# City of Albuquerque Stormwater Construction Site Inspection Report

ESC File No.	N08E006F3	Project Name:	Aspire Subdivision Unit 1 & 2 Houses		
NPDES Id. No.	NMR100490	Location:	11000 Colobel Ave NW		
11/22/2023	Owner	Contractor			
Operator	DR Horton				
Contact name & title	Todd Warmkessel				
e-mail	twarmkessel@drhorton.com				
Contact Phone #	225-4760				
COA Inspector	Doug Hughes		Start/End Time:	8:30 AM	
Construction Phase:	only 2 lots left in Unit 1 and 20 houses started in Unit 2				
Type of Inspection:	<input checked="" type="checkbox"/> Regular	<input type="checkbox"/> Storm Event	<input type="checkbox"/> Post Storm Event >0.25"	<input type="checkbox"/> 311/Complaint <input type="checkbox"/> Follow Up	
Weather at time of inspection?	Clear		Temperature: ~	45	
Estimated date of last storm 0.25" or greater	11/19/2023

ESC-1

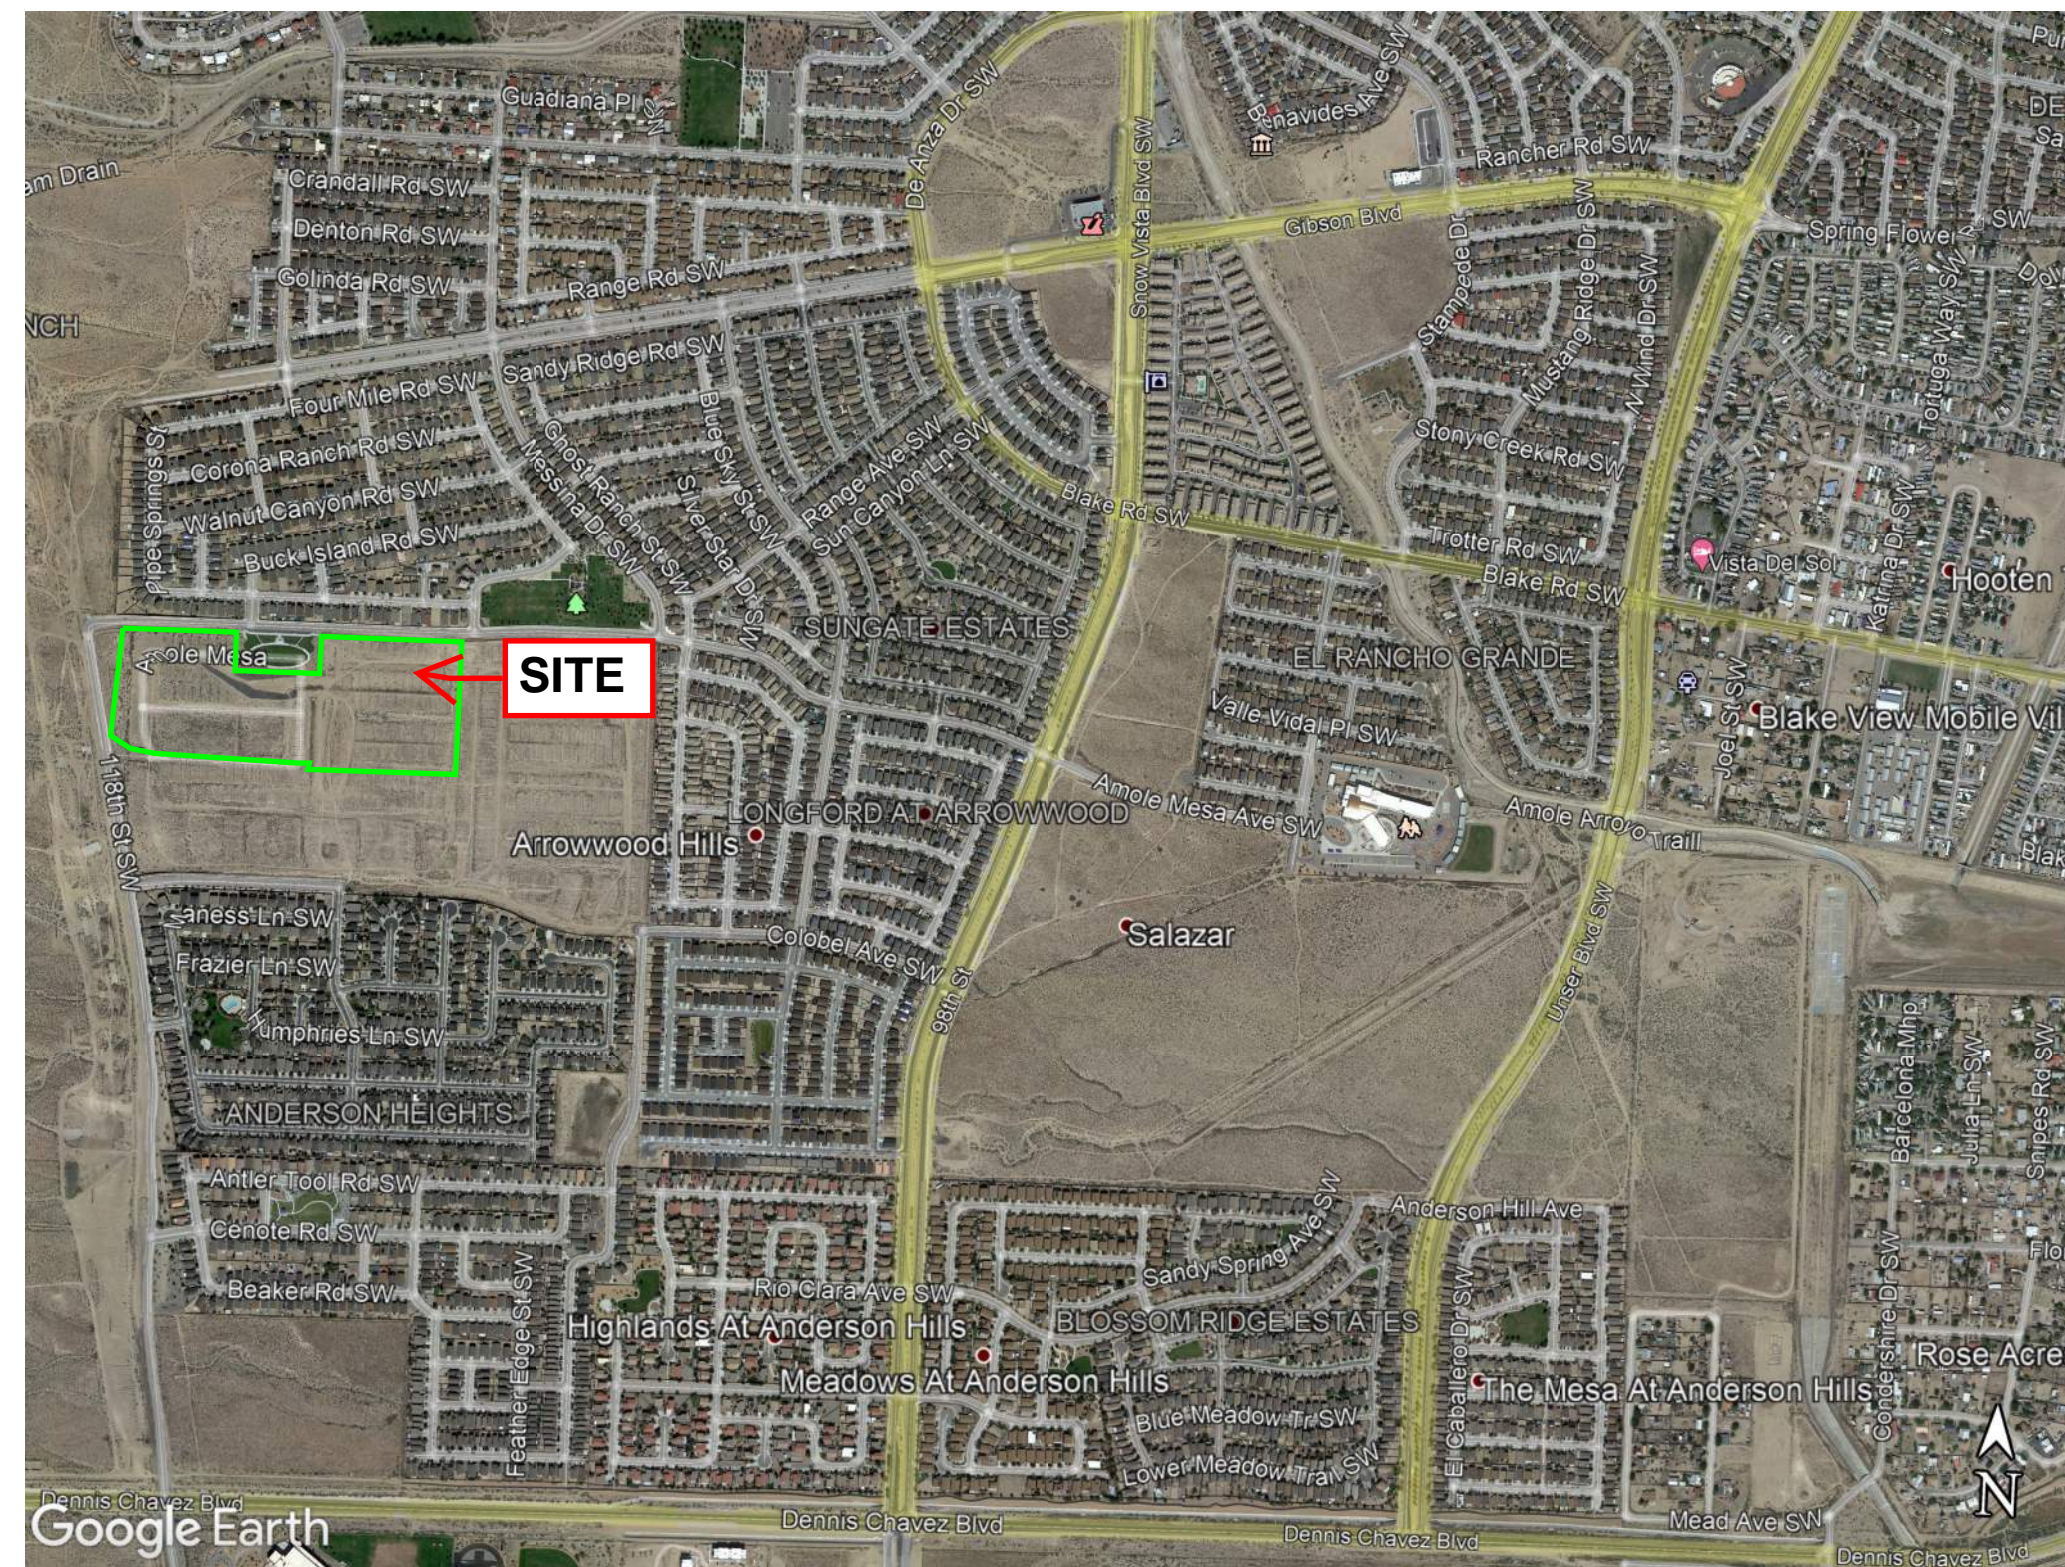
Item Number	Deficiency/ Corrective Action				
	The Posting shows Joseph Cordero and NMR1003LW both wrong. Required Mitigation: Update Posting to Todd Warmkessel at 505-225-4760 and NMR100490.				
	The SWPPP Map should be updated to add check dams or silt fence on each side lot line in the cut-back swales on streets with 2% or more slope. Cutbacks should not be shown where sidewalk is already constructed. The map must also show the Diversion Swale and Sediment Basins on the neighboring property that serve these lots. Consider using approved G&D as base.				
	BMPs the diversion swale on the adjacent property has a breach in the bank that needs to be repaired.
